Recommendation Report for Planning Permission for Works or Extension to a Dwelling

REF NO: M/100/24/HH

LOCATION: 1 Elmer Court
Elmer
Middleton-on-Sea
PO22 6JT

PROPOSAL: Single storey rear pergola and first floor rear balcony with sliding doors. (Part retrospective).

BAR/101

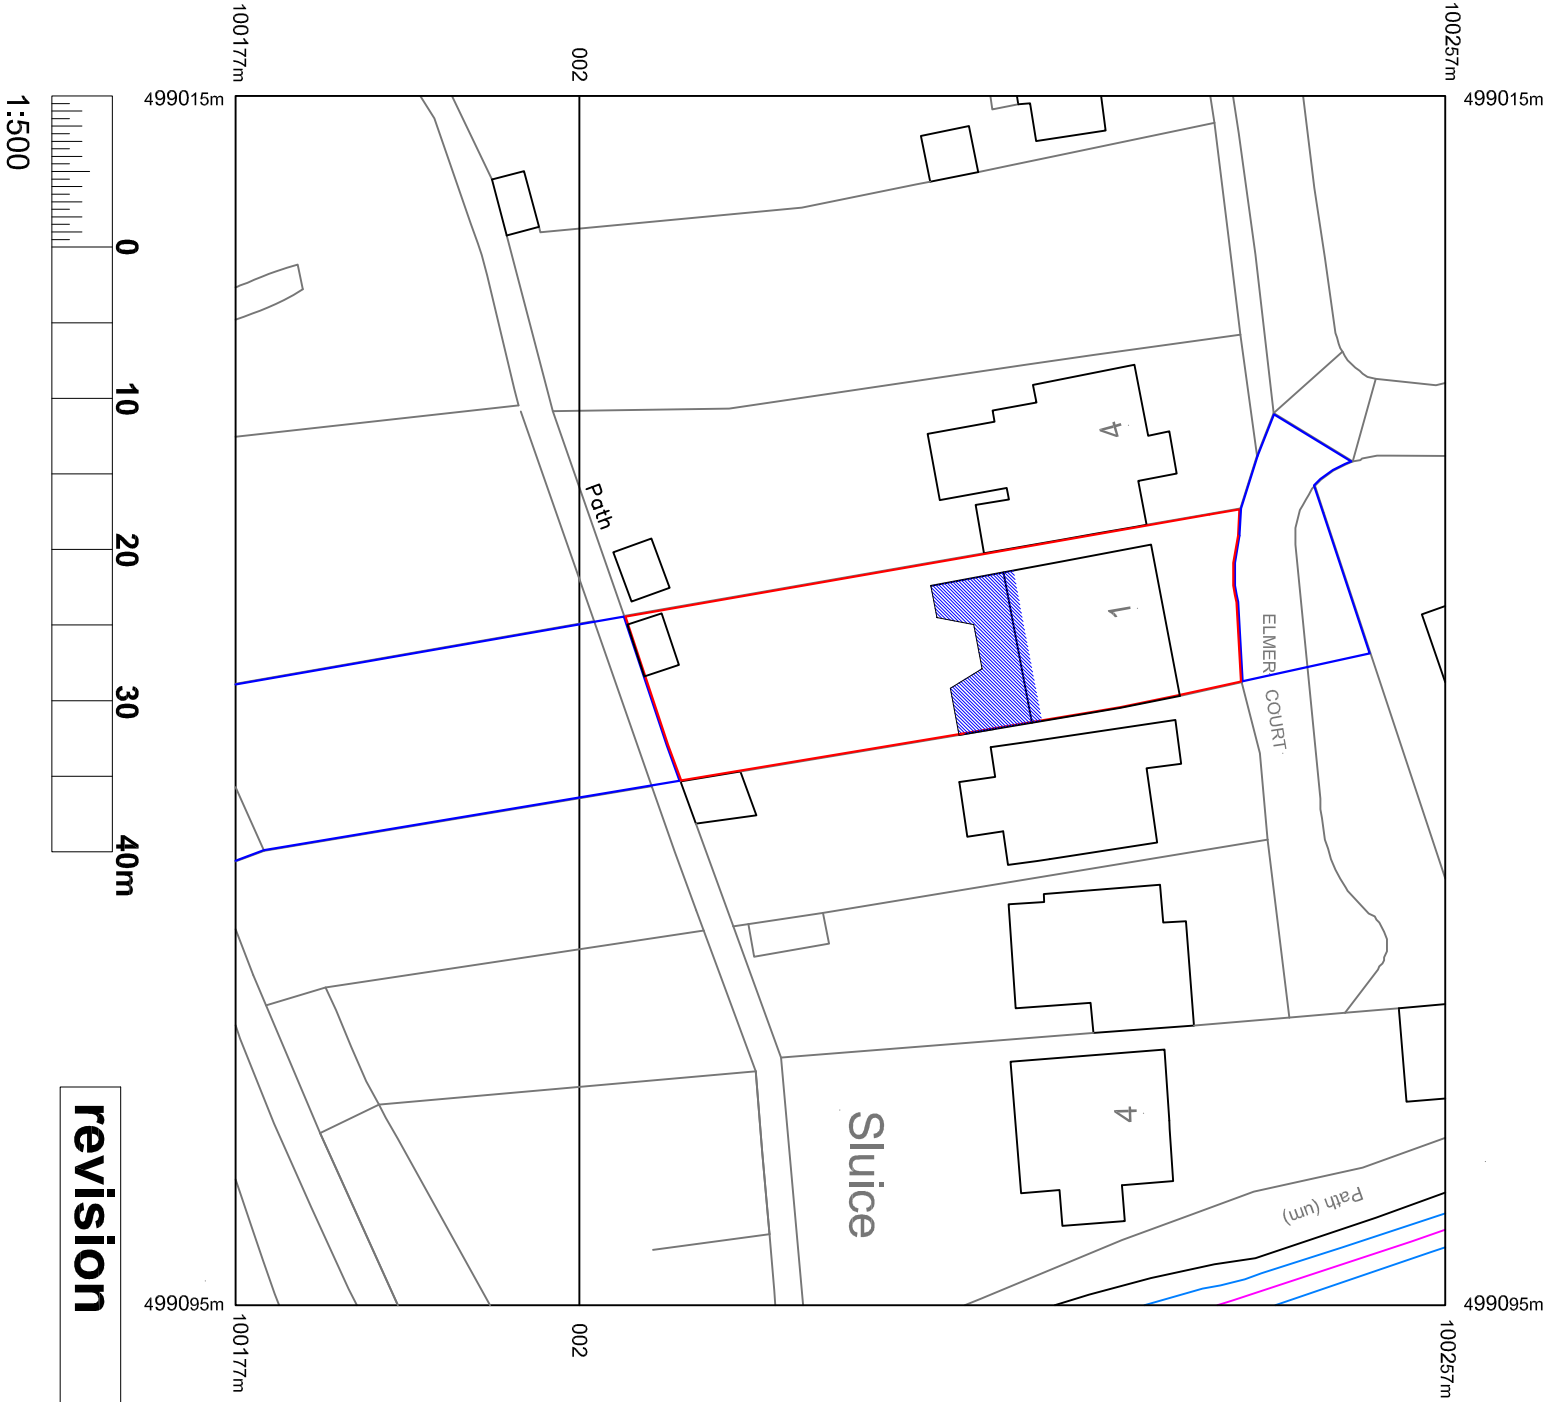
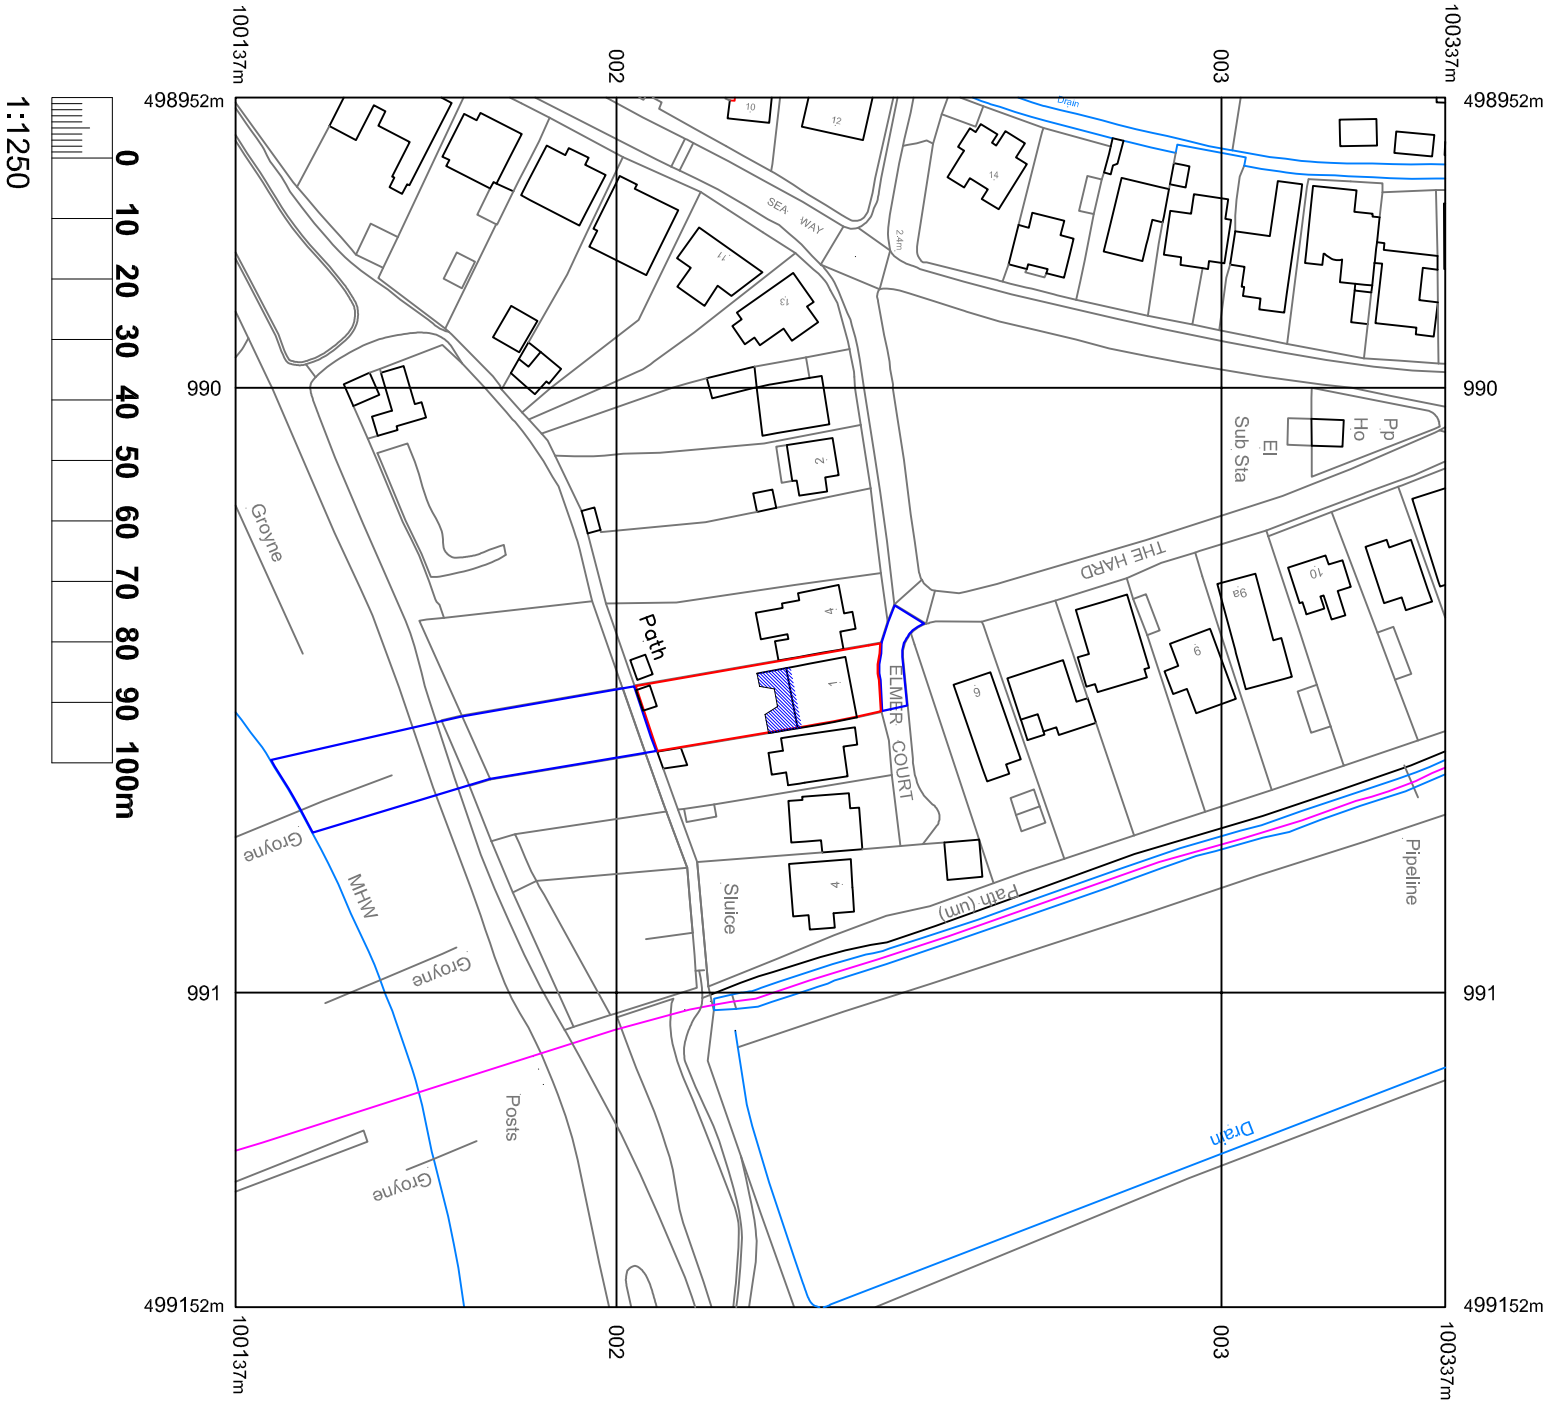
- Submission of inaccurate site plans.
- Solid, substantial structure gives the impression of a permanent extension to the property.
- Terrace-like structure feels imposing, overbearing and perpetual feeling of being overlooked.
- This roof terrace is essentially too large and too close to the neighbouring properties.
- Breach of the surrounding neighbour's privacy, and the setting of an unwelcome precedent for the rest of the estate.
- The new doors are not central to the roof but at each end, causing unacceptable lost privacy to both neighbour's immediate rear private spaces.
- The height at the boundaries is 3.2m. With the addition of necessary safety railings /privacy screen of a minimum 1.8m, this would result in a 5m high structure built up to both boundaries.
- No railings around the edges.

Comments noted, amended site plans were sought but inaccurate site plans were submitted. Details of the railings were initially not submitted but on request, amended plans were submitted detailing the location of balustrading.

It is accepted that the amended plans would be an improvement on what was initially proposed. Due to the submission of inaccurate site plans it is not possible to fully and accurately assess the impact of the development on the host dwelling or wider area. A 1.8m wood panel side screening is proposed at first floor level, the wooden panelling will appear extremely overbearing in its context and will alter the character of rear elevation of the dwelling significantly.

The first floor balcony and pergola is considered to result in a scheme detrimental to the character and appearance of the host dwelling which is further exacerbated with the submission of inaccurate site plans to assess the actual impact on the neighbouring dwellings in its entirety, contrary to D DM1, D DM4(a) and (b) of the Arun Local Plan, Part M Arun Design Guide and the National Planning Policy Framework and as such the application is recommended for refusal for the below reason.
